City of Albuquerque Stormwater Construction Site Inspection Report

General Information						
ESC File No.	A11E011J	Project Name:	McMahon 9C & D			
NPDES Id. No.	NMR10069S	Location:	5770 McMahon Blvd NW			
2/17/2026	Owner	Contractor				
Operator	JMD - McMahon, LLC					
Contact name & title	Doug Peterson					
e-mail	doug@petersonproperties.net					
Contact Phone #	505-884-3578					
COA Inspector	Chancellor English		Start/End Time:	1:45pm		
Construction Phase:	Inactive - preconstruction					
Type of Inspection:	Regular	Storm Event	Post Storm Event >0.25"	311/Complaint	Follow Up	
Weather at time of inspection?	Windy		Temperature: ~	50		
Estimated date of last storm 0.25" or greater	1/8/2026

TEMPORARY EROSION AND SEDIMENT CONTROL PLAN

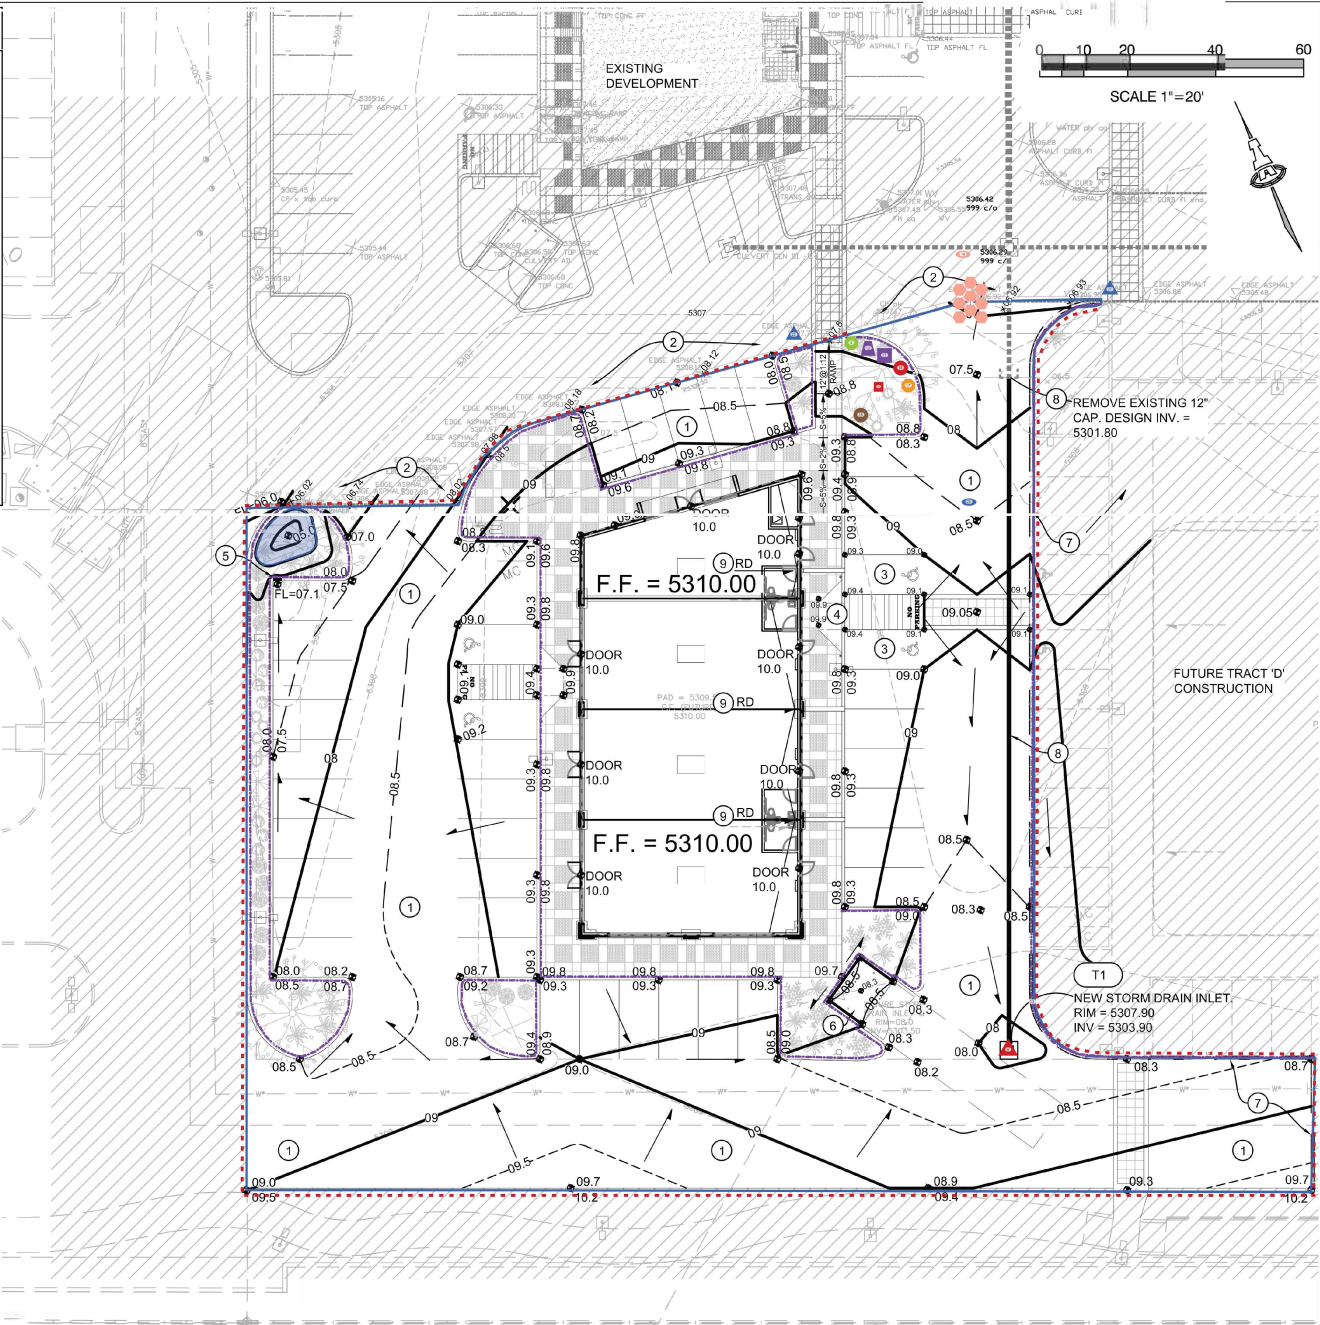
Item Number	Deficiency/ Corrective Action					
1	Washout - Concrete washout was found in several areas of your property in violation of CGP Part 2.3.4. Required mitigation: Direct wash water into a leak-proof container or a leak-proof and lined pit designed so that no overflows can occur due to inadequate sizing or precipitation per CGP Part 2.3.4. Do not allow for liquid wastes to be disposed of through infiltration or to otherwise be disposed of on the ground. Remove and dispose of hardened concrete waste consistent with your handling of other construction wastes.					
2	BMPs - The perimeter silt fence is in disrepair in violation of CGP Part 2.1.4. Required mitigation: Ensure all stormwater controls are maintained and remain in effective operating condition during permit coverage and are protected from activities that would reduce their effectiveness per CGP Part 2.1.4.
